East Anglia One North (EA1N) and East Anglia Two (EA2) Offshore Wind Farms

Planning Inspectorate Reference: EA1N – EN010077, EA2 – EN010078

Deadline 1 - 2 November 2020

East Suffolk Council's and Suffolk County Council's Response to Examining Authority's
First Round of Written Questions

## East Anglia ONE North

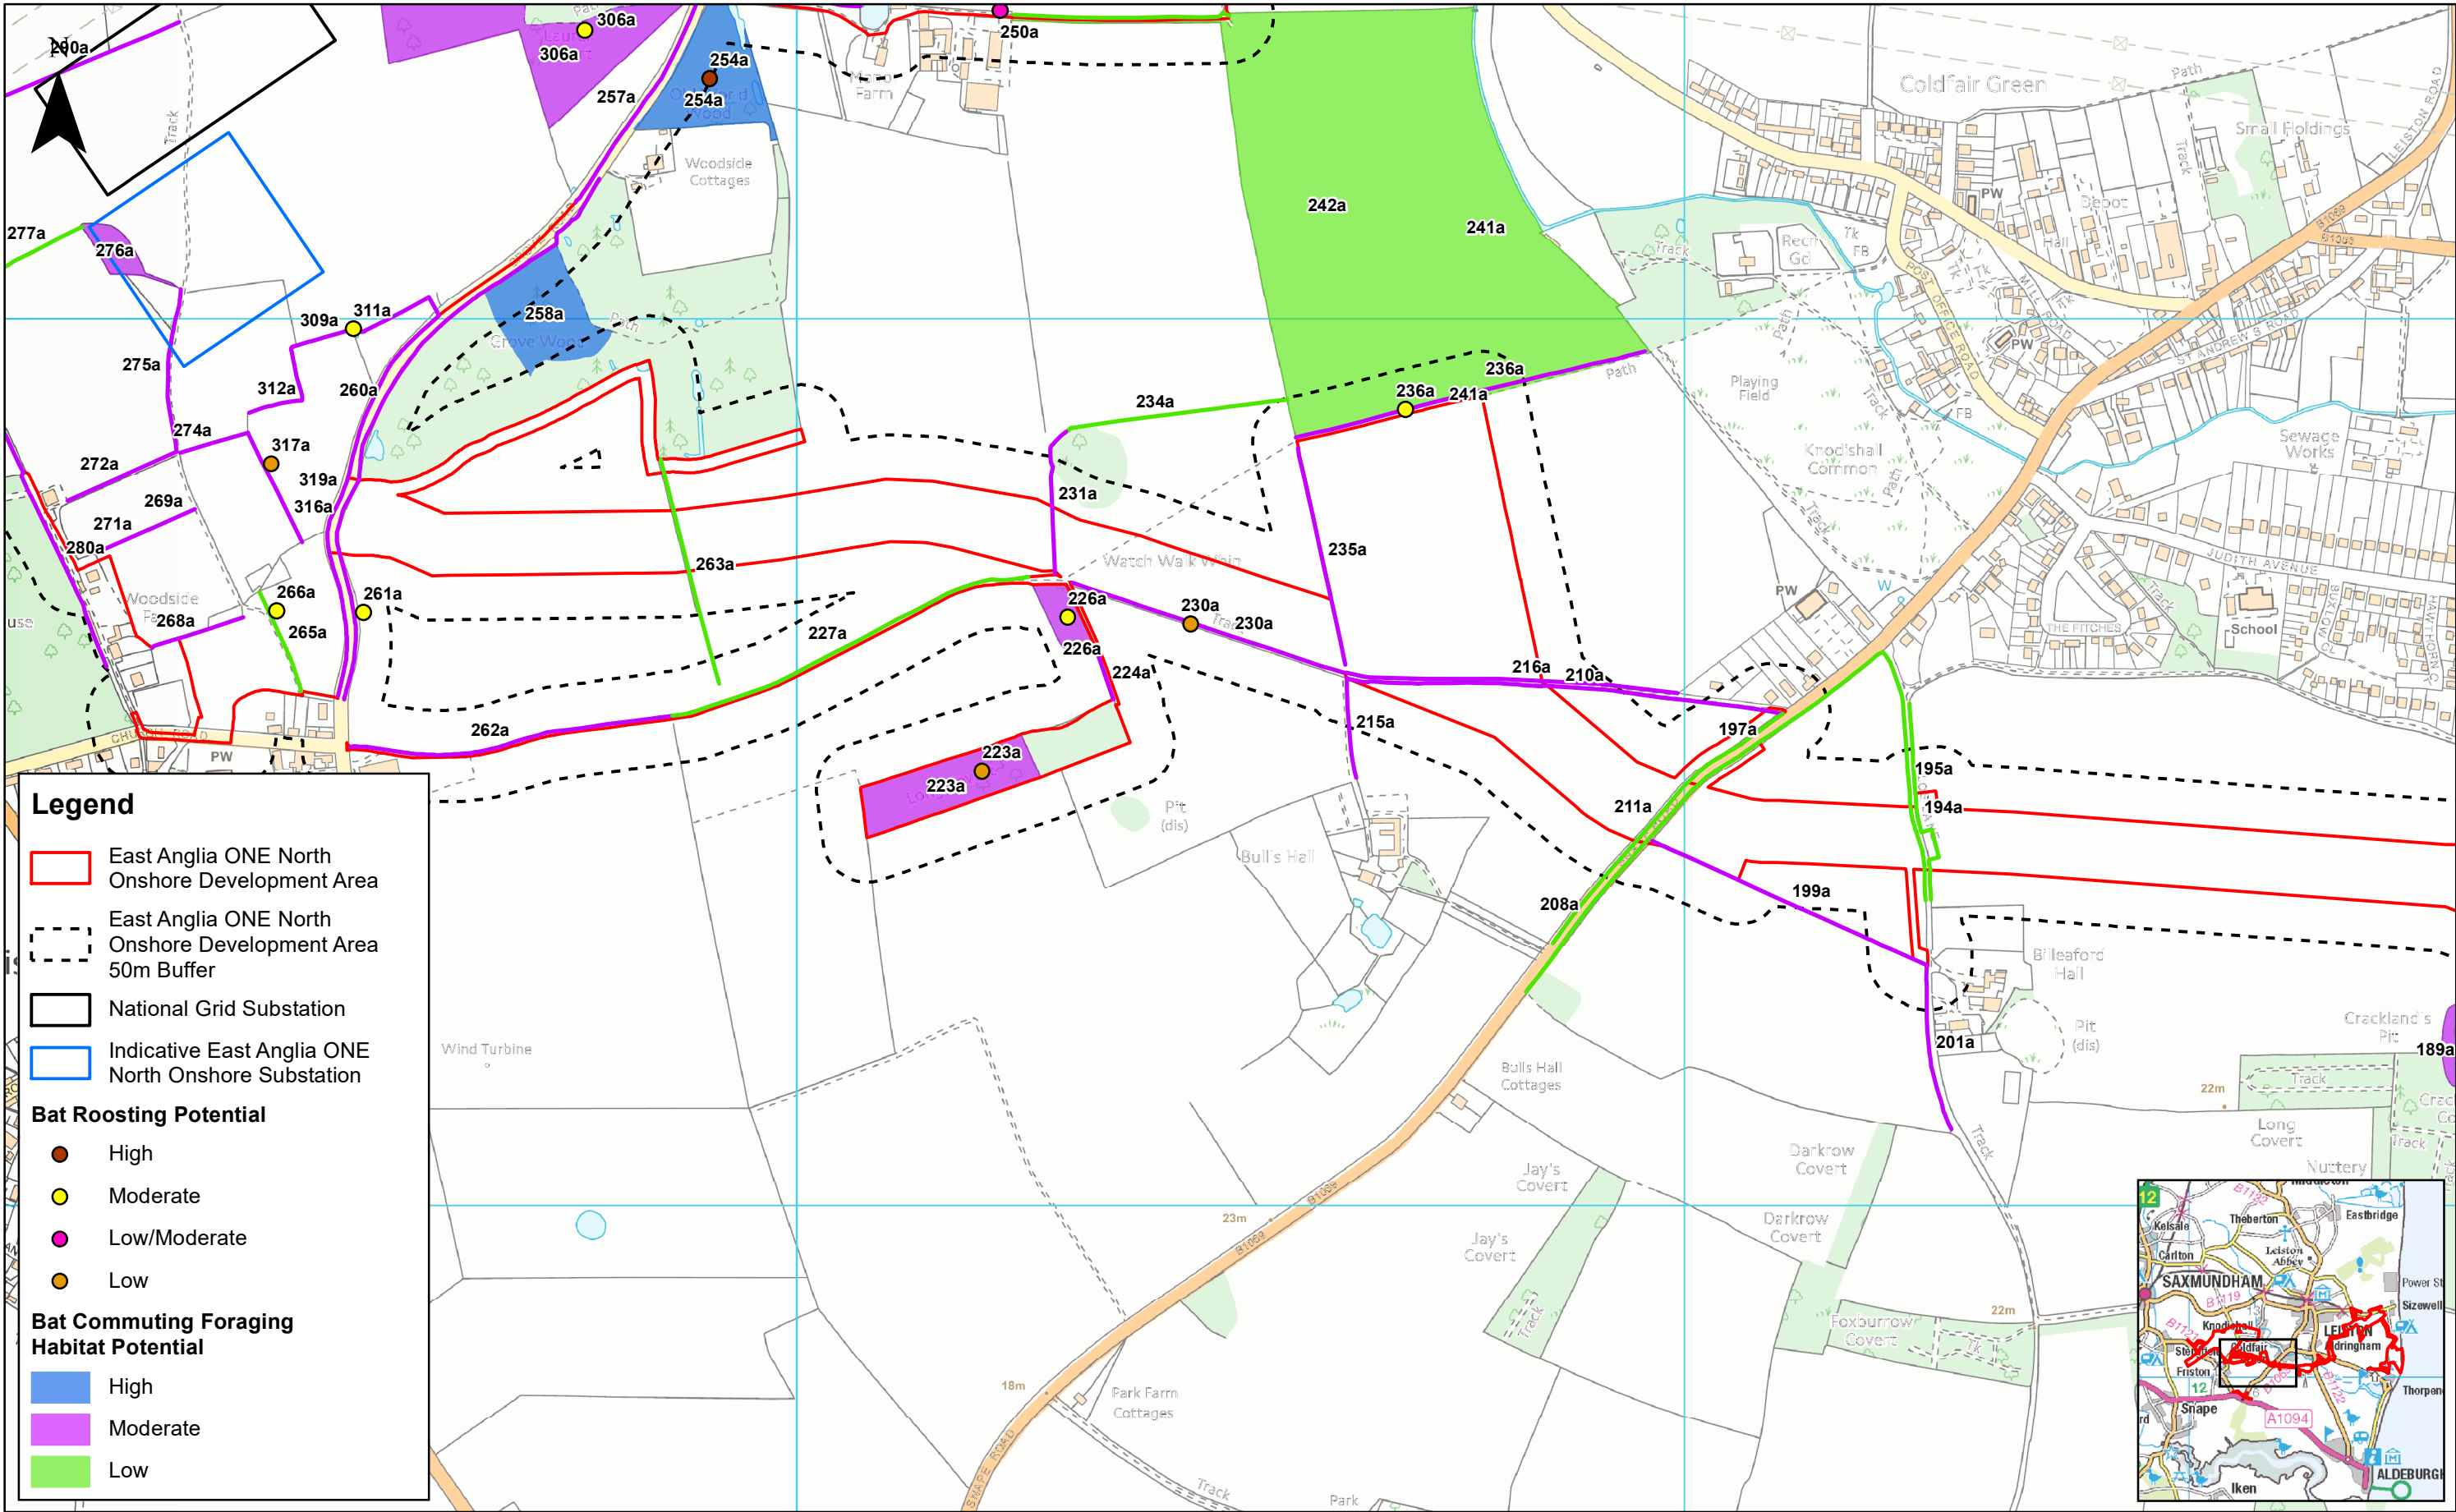
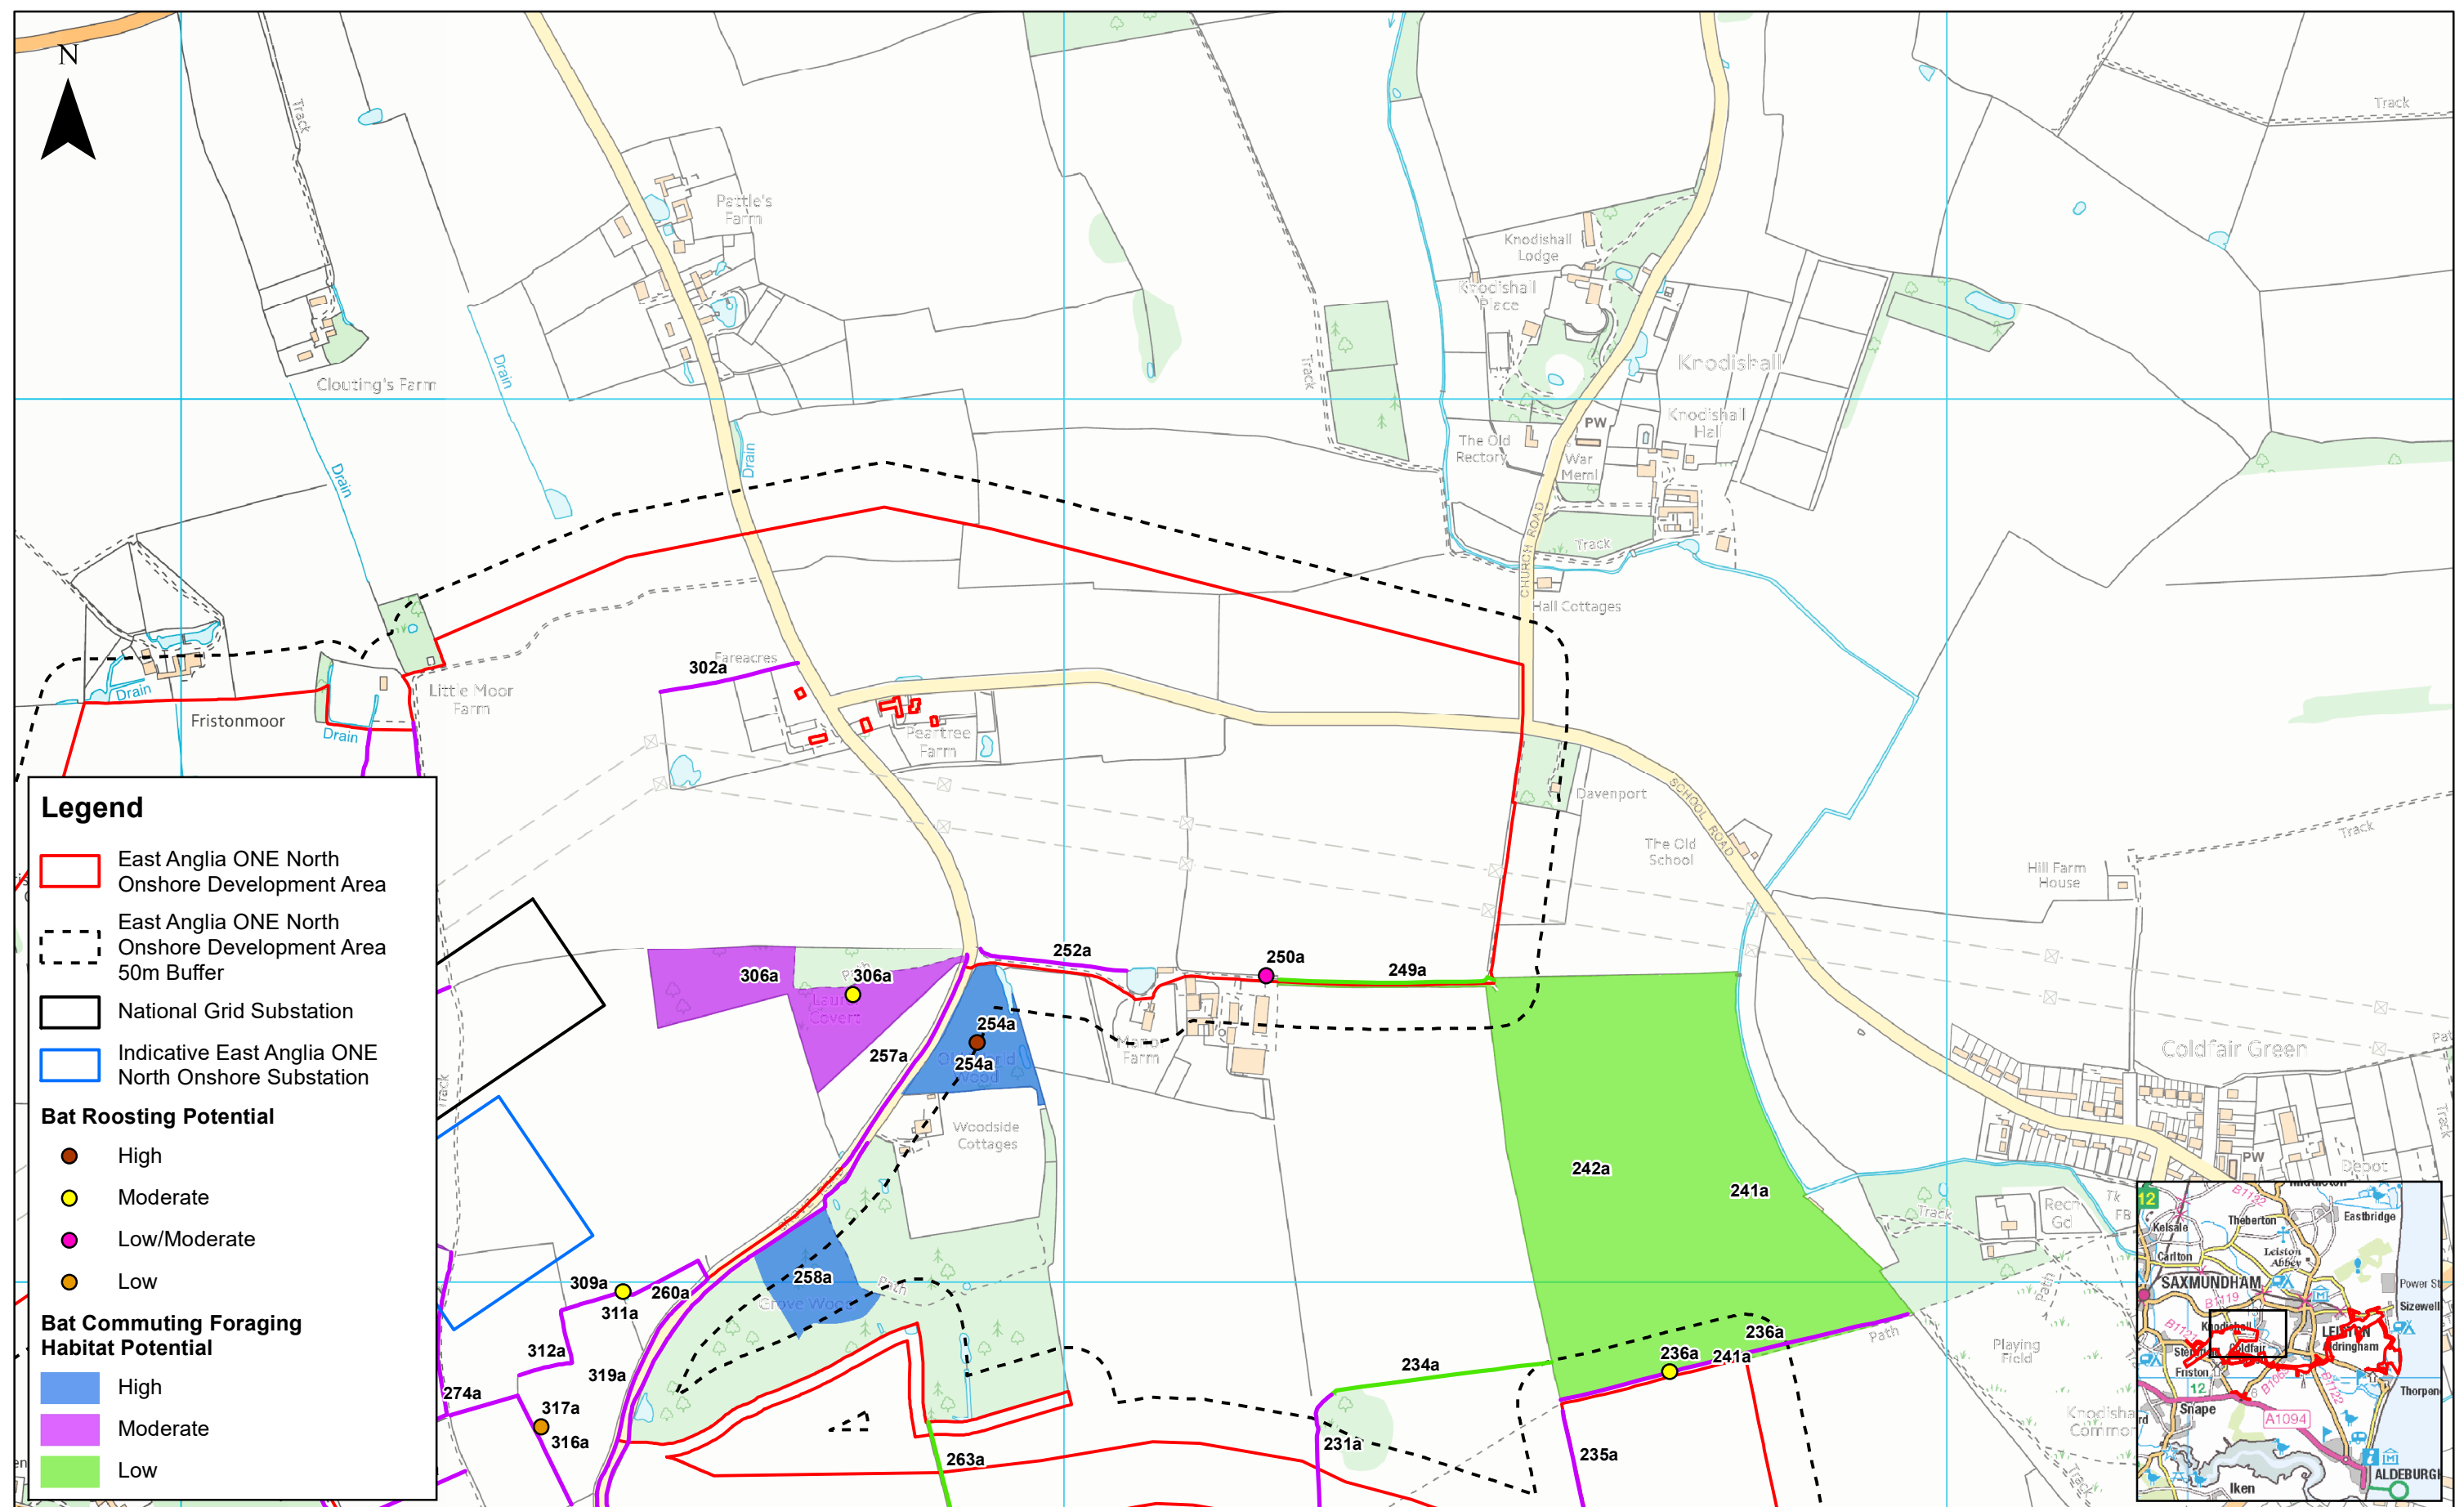
<p>transects were chosen? Why was long covert excluded from transect 2 [APP-281]?</p> <p>f) Could the Applicant confirm if they intend to submit an outline hedgerow mitigation plan?</p> <p>g) Are Natural England/ESC/SCC/Suffolk Wildlife Trust satisfied that the reinstatement, management and maintenance of the replacement hedgerows is satisfactorily secured? Should this be contained within the LMP or EMP?</p> <p>h) Can the Applicant please confirm when an updated CIA with Sizewell in relation to bats will be submitted into the Examination?</p> <p>Please can Natural England confirm that they are satisfied that Figure 22.7a-g [APP-280] clearly maps the roosting, foraging and commuting areas for bats in relation to the red line boundary?</p>
